26 May 2025

Our ref: SSD-4/2025

194-214 Oxford Street and 2 Nelson Street, Bondi Junction - SSD-77175998

Figure 21: Wind amelioration measure overlaid on the ground floor plan.

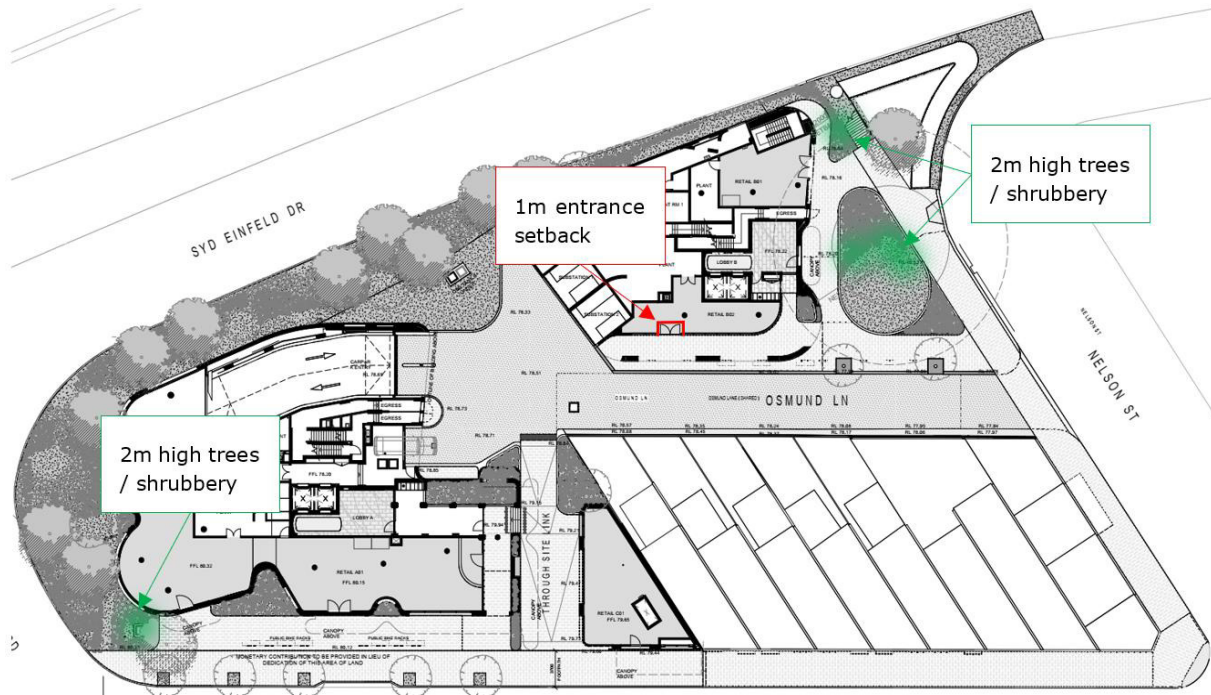
The Secretary’s Environmental Assessment Requirements (SEARs) dated 25 October 2024 required a Pedestrian Wind Environment Assessment be provided to assess amenity impacts on the surrounding locality, including wind impacts. The proposal is accompanied by a report titled ‘Pedestrian Level Winds – Wind Tunnel Test’ dated 1 April 2025 compiled by Vipac Engineers and Scientists Limited. The report makes recommendations to ameliorate adverse winds impacts, which have been omitted from the architectural drawings.
